DELEGATED HOUSEHOLDER DECISION

Address: 46 WILLOW GROVE RUISLIP

Development: Demolition of existing extension and conservatory. Erection of a single rear extension. Extension and conversion of roof space to habitable use including both sides conversion from hip to gable/half hipped end and raising of the roof ridge. Installation of 2 no. front and 2 no. rear dormers. Erection of a porch.

LBH Ref Nos: 49093/APP/2023/314

FRONT ELEVATION - PROPOSED

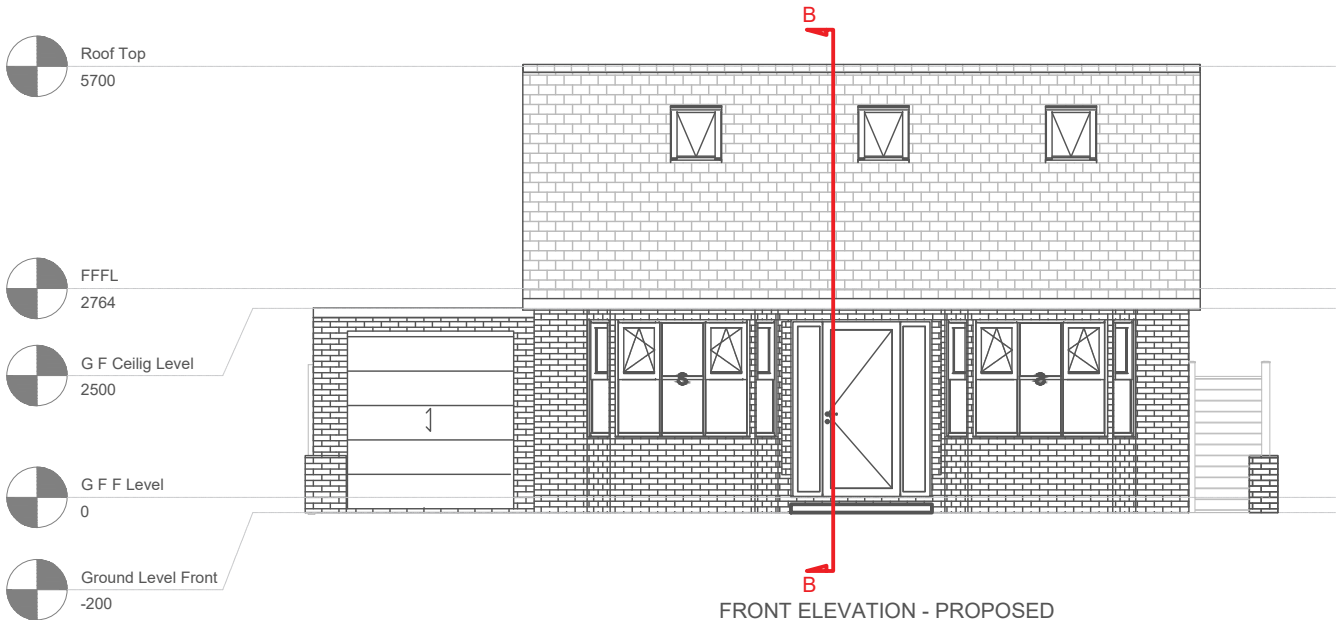
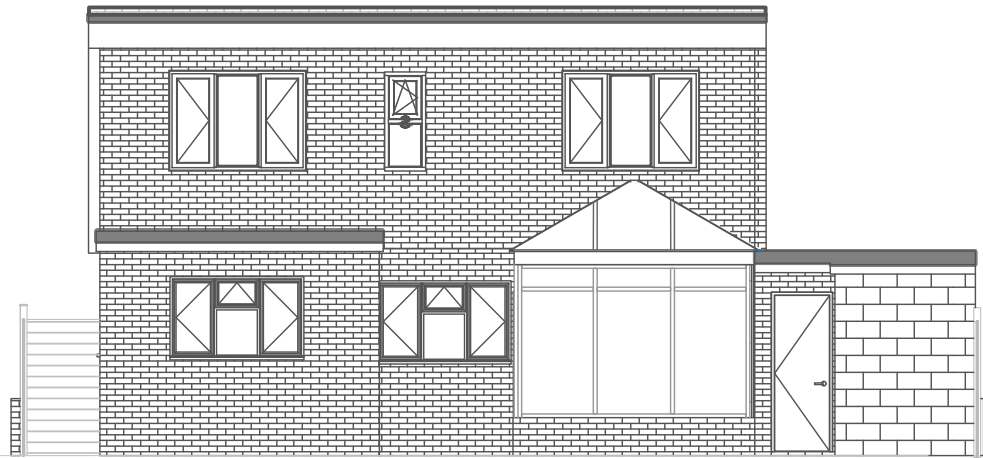
The building height would be raised 30cm to 6metres. From the planning history, both adjacent neighbours No.44 and No.48 (which has a hip-to-gable roof alteration) are 5.4metres in building height. A street section drawing has not been provided to demonstrate the effect on the neighbouring properties. However it is apparent that the development proposal would be notably taller than both neighbours and of a significantly different design. Having regard to the immediate site context, it is considered that due to the increase in building height and design, the development proposal would be visually prominent in the street scene and fail to harmonise with the architectural composition of the host dwelling.

The rear dormers would be 5metres in depth and the front dormers 3.5metres in depth. Both would be set back 1.35metres behind the eaves. A 20cm set down from the raised roof ridge would be provided. Overall, the dormers are considered to represent bulky features thereby worsening the visual prominence of the development proposal within the street scene.

Having regard to the adjacent neighbouring properties, the proposed increase the building height and the alteration of the existing main hipped roof of the dwelling to provide half hipped gable ends on both sides, combined with the large oversize front and rear dormers, is in this instance, considered to be harmful on the character and appearance of the area.
